Epping to Thornleigh Third Track Proposal. Application number SSI 5132.

I/we object to the Epping to Thornleigh Third Track Proposal and consider that the EIS is inadequate and does not address the full impact of this proposal. It will cause untold damage to the health of residents and to the fabric of the Beecroft Cheltenham Heritage Conservation Area. Do not approve this project, reconsider the alternatives and protect the community.

Figure S.6 Cross-section and elevation - New Cheltenham Station concourse building (see also S.5 for artist's impression)

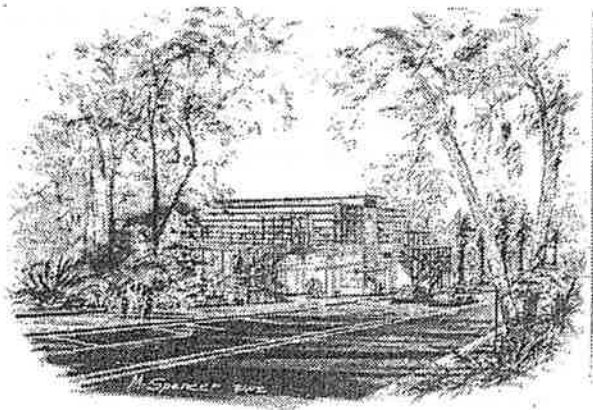
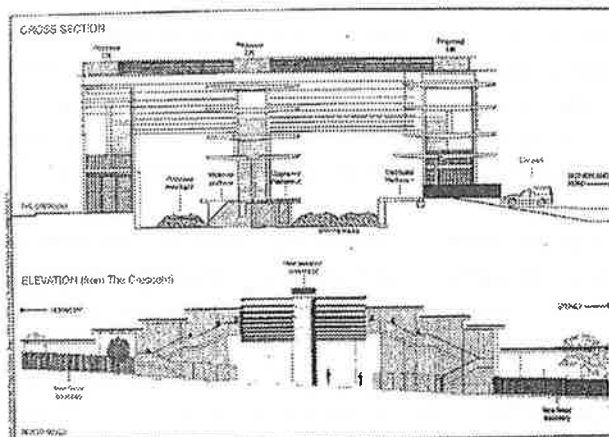
- The proposed redevelopment of Cheltenham Station shows no regard for the HCA. The visual impact of the proposed 13m high glass and steel concourse is totally unacceptable in this HCA.

The ETTT proposal imposes a two storey, 13m high, railway concourse at Cheltenham to be positioned near the entrance to the current car park. It will have lift and stair access to all platforms, a bus bay and taxi rank. The indicative design shown in the EIS is a glass and steel structure. This is totally inappropriate for a Heritage Conservation Area and indicates that the designers either ignored or were unaware of the HCA. The only time buses come to Cheltenham Station is when they are replacing rail. There has never been a taxi rank at Cheltenham, nor any need for one.

The EIS considers that this huge structure is *'unlikely to have significant impacts on the heritage values'* of the houses opposite, mainly because some of them will be screened by vegetation.

Figure 5.3 Future Cheltenham Station layout

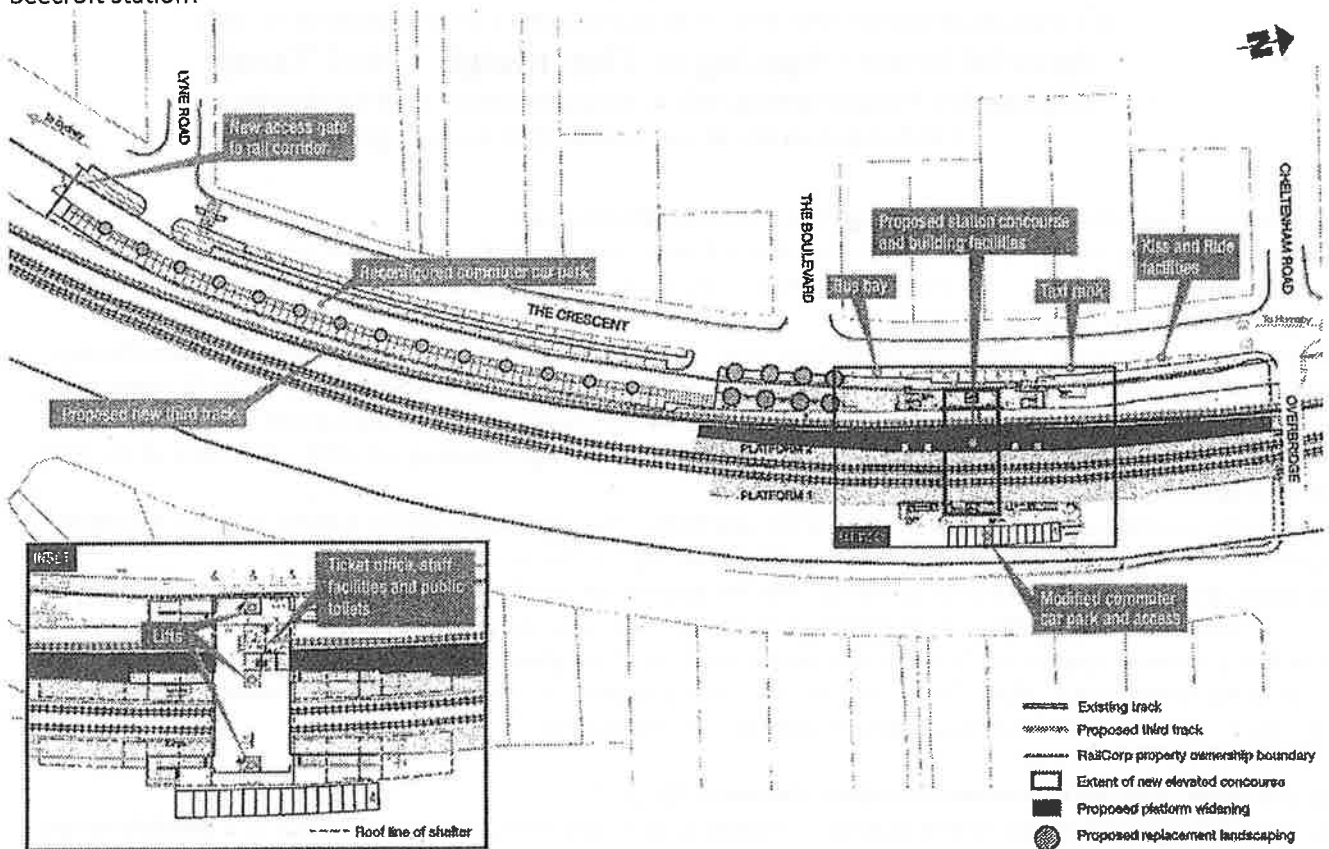
The car park on the western side will be extended almost to Lyne Road which will increase walking distance and impact on the Cheltenham Recreation Club. Parking in The Crescent adjacent to the station is removed.

Rock will be removed from the cutting under the western side of the road bridge which will be strengthened.
